DELEGATED DECISION TO DETERMINE PLANNING APPLICATIONS

Reference No:	2025/62/93504/W
Site Address:	2, Peace Hall Drive, Fenay Bridge, Huddersfield, HD8 0BP
Description:	Demolition of existing conservatory and erection of single storey rear extension and front porch with associated alterations
Recommending Officer:	Molly Storer

HOUSEHOLDER DELEGATED REPORT

AS PROPOSED, FLOOR PLANS + ELEVATIONS

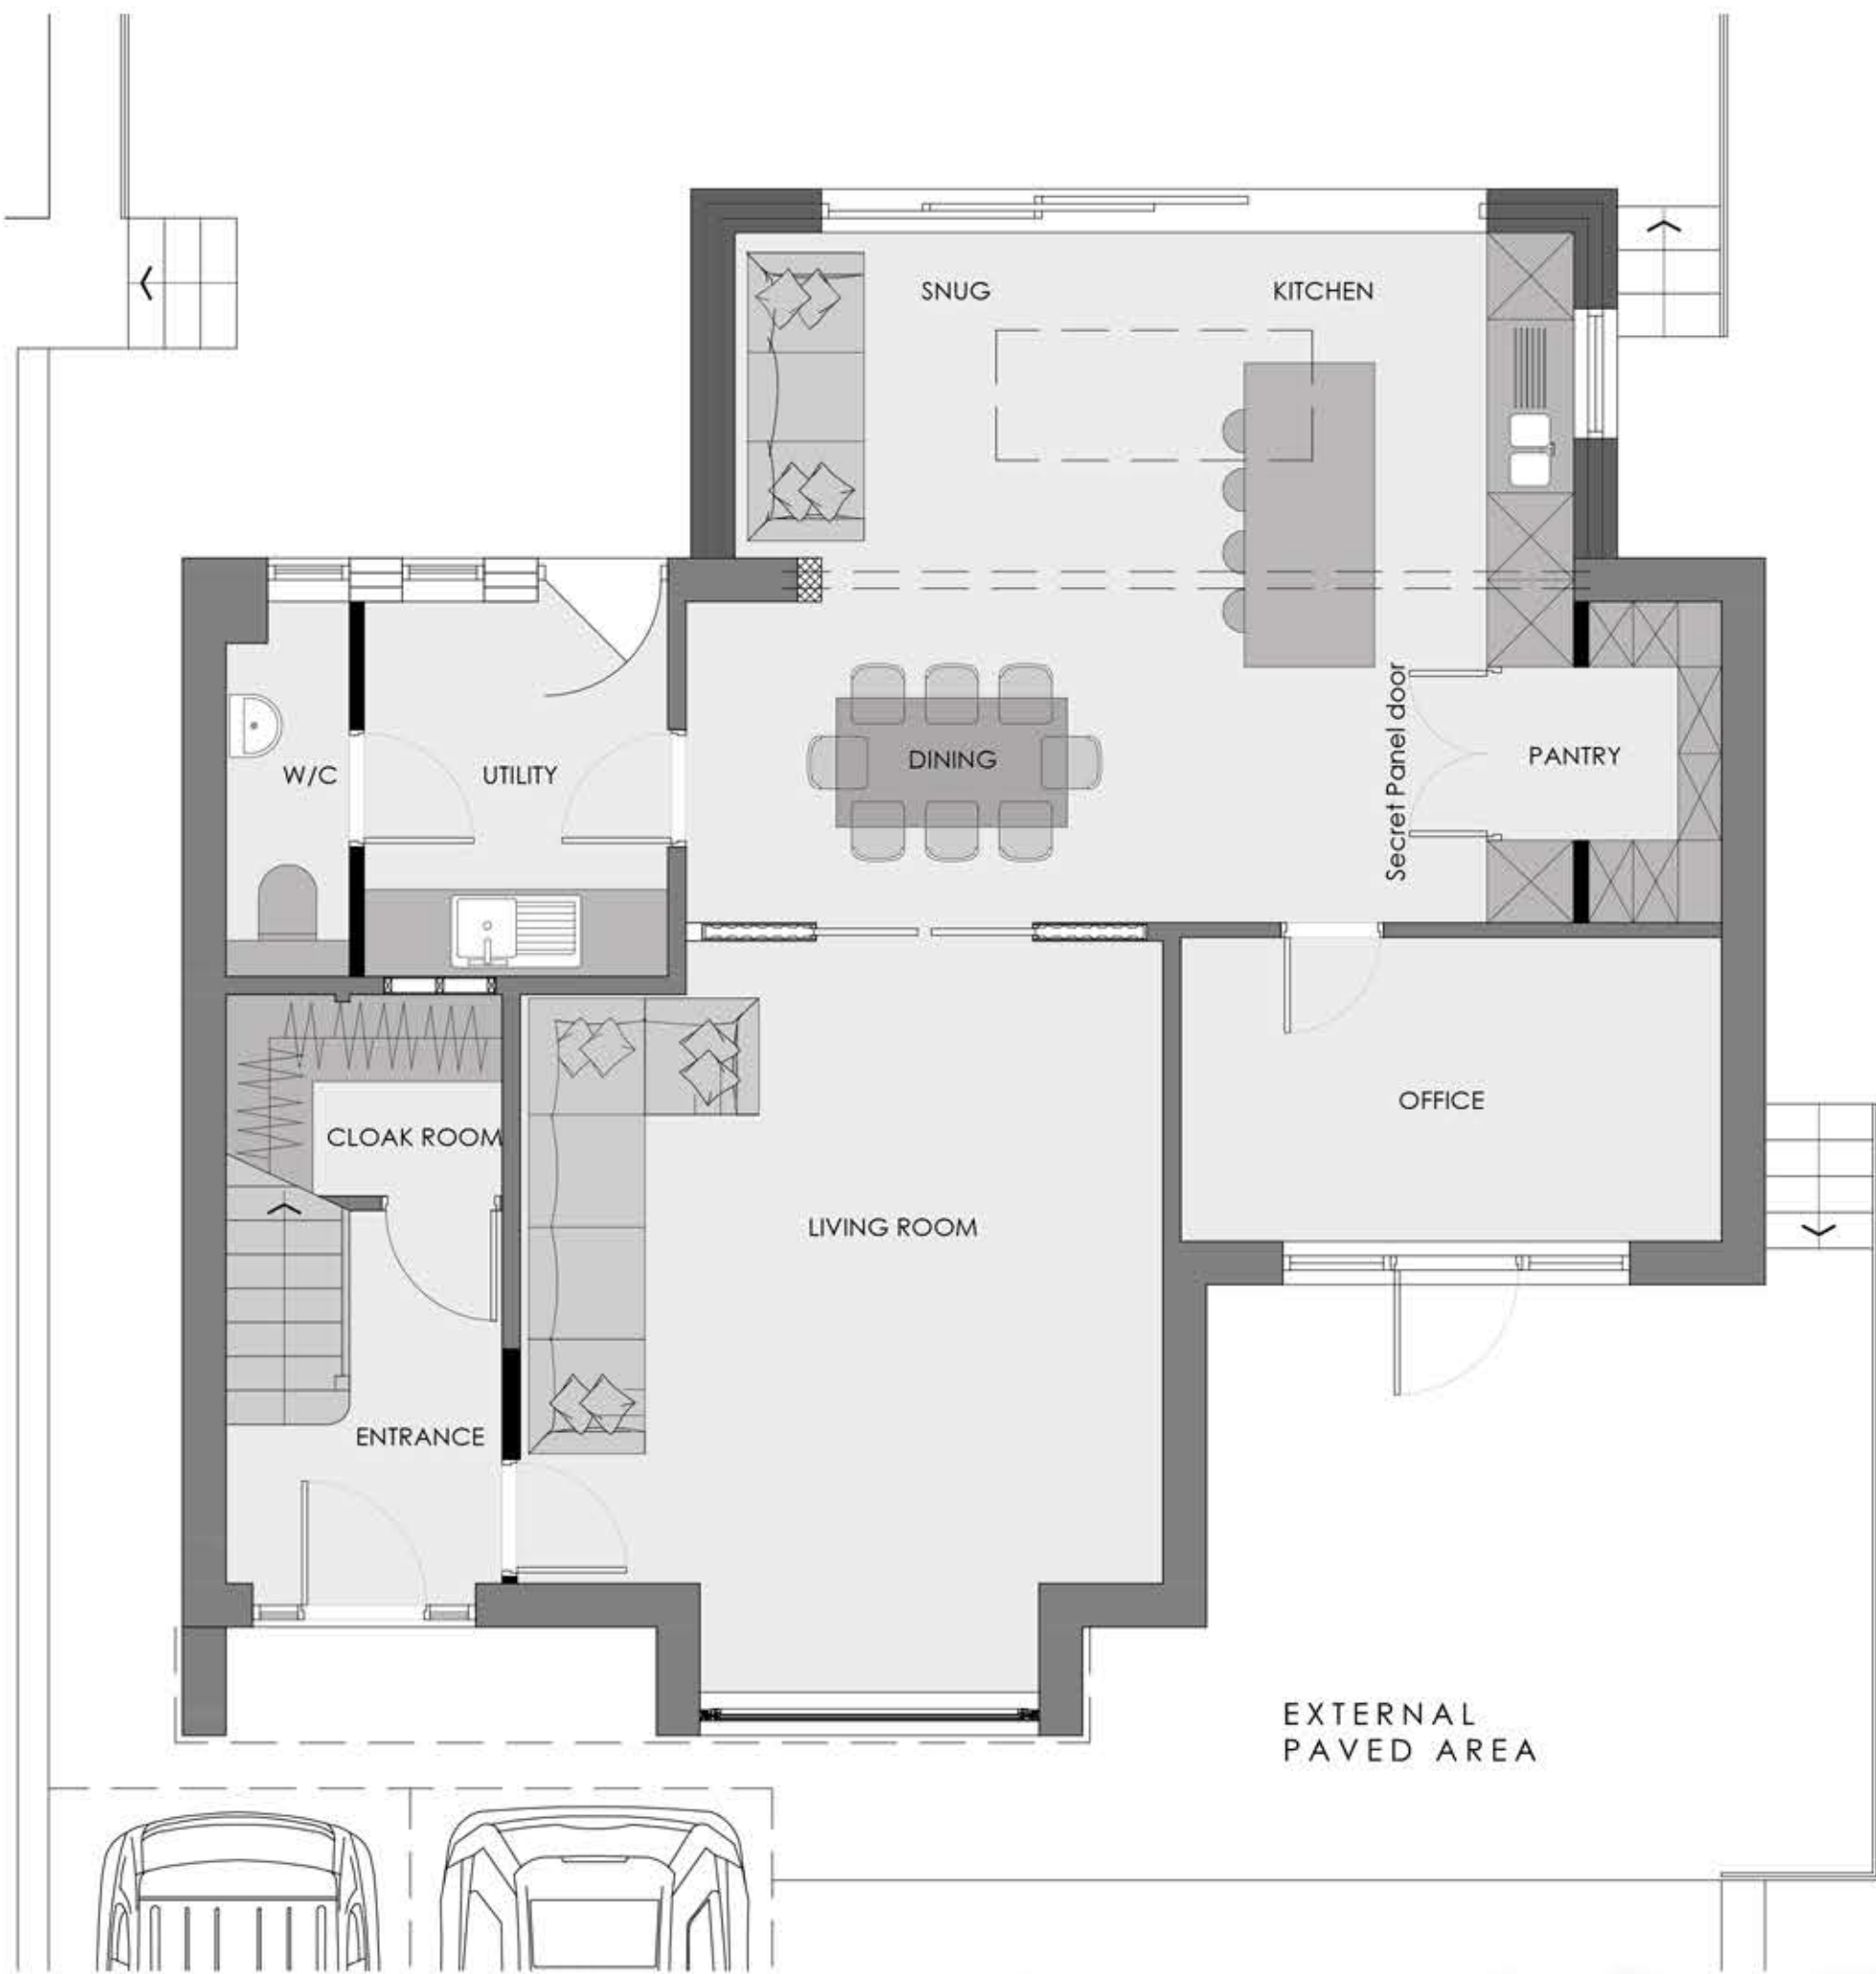
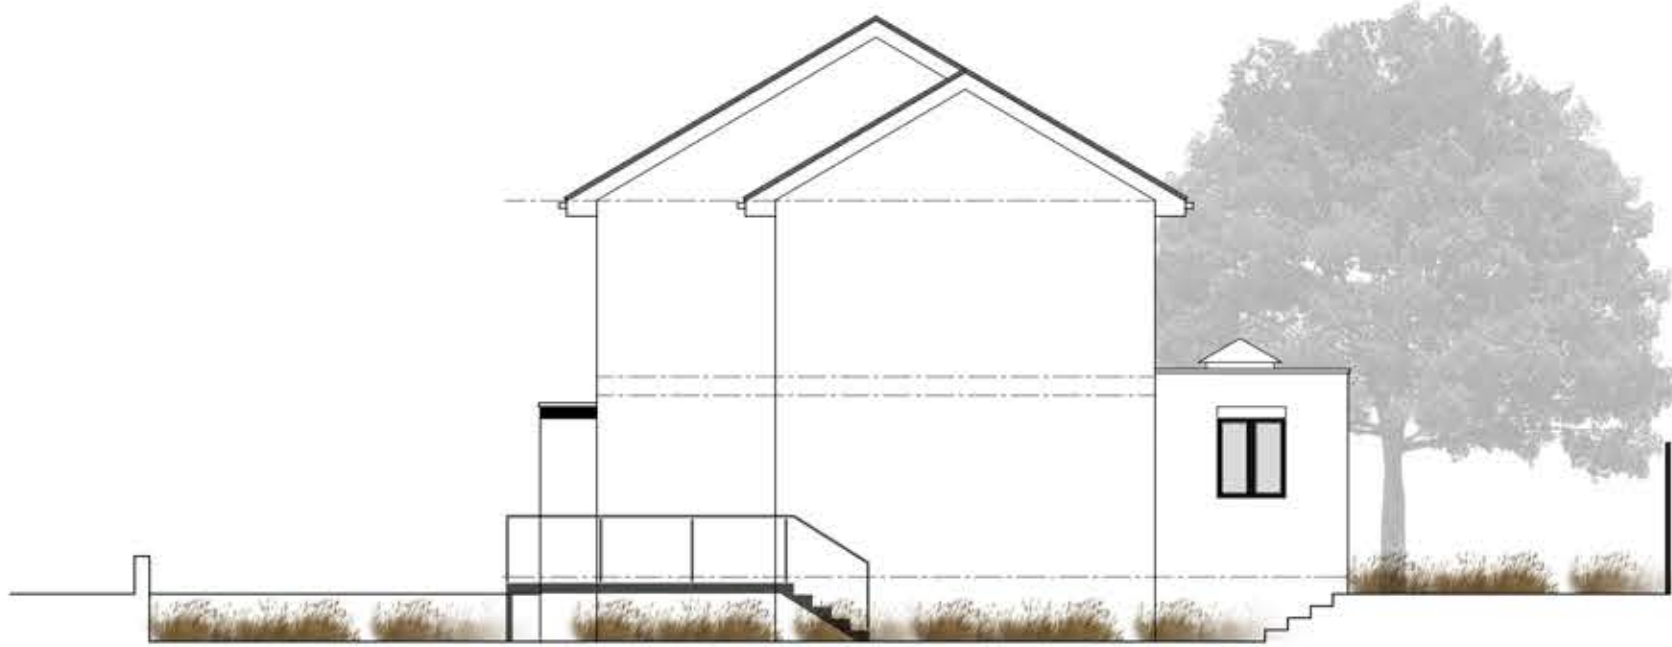
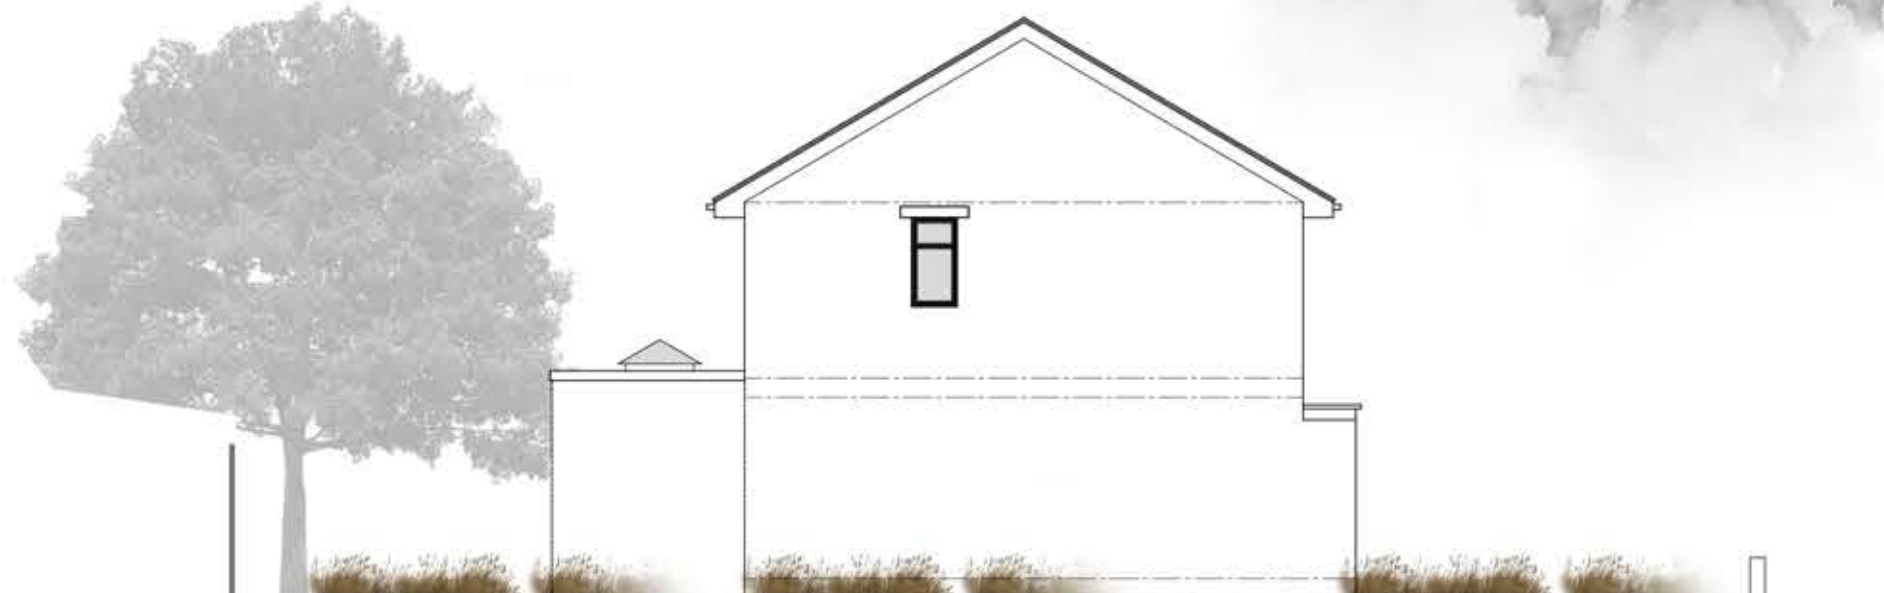
The rear extension would be on a similar footprint to the conservatory currently at the property. It would project 2.55m from the rear of the dwelling and would have a width of 6.4m. The height would be 3m from the rear decking level and 3.5m from the level of the front of the house. It will have a flat roof design with a roof lantern.

The front extension will be in the place of a bay window and will extend 0.65m from the front of the house and will have a width of 3m. It will have a height of 2.65m and a flat roof design which will carry over to a canopy which will cover the front entrance door.

Impact on the Local character and street scene	• KDP1 of the SPD • Policy LP24 Design (a) and (c) of the KLP • Chapter 12 NPPF	The rear element will have limited views from public vantage points as it will be located to the rear and will be set well in from the elevations. The rear extension is a distance / design such that it is concluded to have an acceptable impact upon the street scene. The front extension will be limited in scale and other front extensions are seen within the streetscene resulting in no harmful visual impact.	
Impact on original house	• KDP2 of the SPD • Policy LP24 Design (c) and (d) of the KLP • Chapter 12 of the NPPF	Considered to be acceptable on the basis both being single storey and constructed from harmonising and acceptable materials as well as the removal/replacement of the existing conservatory in way of the rear extension.	
Height, scale and massing	• KDP 1 and 2 of the SPD • Policy LP24 Design (a), (c) and (d) of the KLP • Chapter 12 of the NPPF	Both single storey in height with the front element only extending 0.65m and the rear element replacing the existing conservatory.

Facing materials and detailing	• KDP 9 of the SPD • Policy LP24 Design (d) (iii) of the KLP • Chapter 12 of the NPPF	The proposed materials for the scheme are to be timber cladding and white render. Whilst cladding is present on the existing house, render will introduce a new material. However, the timber will tie in the render creating a harmonious design which will reflect the modern renovation of the property.

Roof style	• KDP 1 and 2 of the SPD • Policy LP24 Design (a), (c) and (d) of the KLP • Chapter 12 of the NPPF	Simple flat roof design considered acceptable.	
Window proportions	• KDP 1 and 2 of the SPD • Policy LP24 Design (a), (c) and (d) of the KLP • Chapter 12 of the NPPF	Windows proposed in the front and rear elevations and one window is proposed to the west side elevation of the rear extension. Due to this replacing excessive glazing on the conservatory this is considered acceptable.	
Accessibility for all users	• KDP 17 of the SPD • Policy LP24 Design (f) • Chapter 12 of the NPPF	Private domestic extension – no alterations to general access arrangements

Due to the topography of the street this property is situated on a significantly higher ground level. There are no additional windows facing this property and the rear extension would maintain a separation distance of over 4m to the property boundary – the same as the existing conservatory. Therefore, there is considered to be no significant impact to this property.

Impact to this property would be limited due to it facing onto a blank side elevation at this property. In any case, a separation distance of ~16m would be maintained and the glazing in the front elevation would only be brought forward by 0.65m.

Although there will be a window in the elevation facing these properties, this will replace excessive glazing from the current conservatory and is therefore considered to improve privacy. A separation distance of over 15m and no significant additional bulk and massing will mean there is no significant impact to these properties.
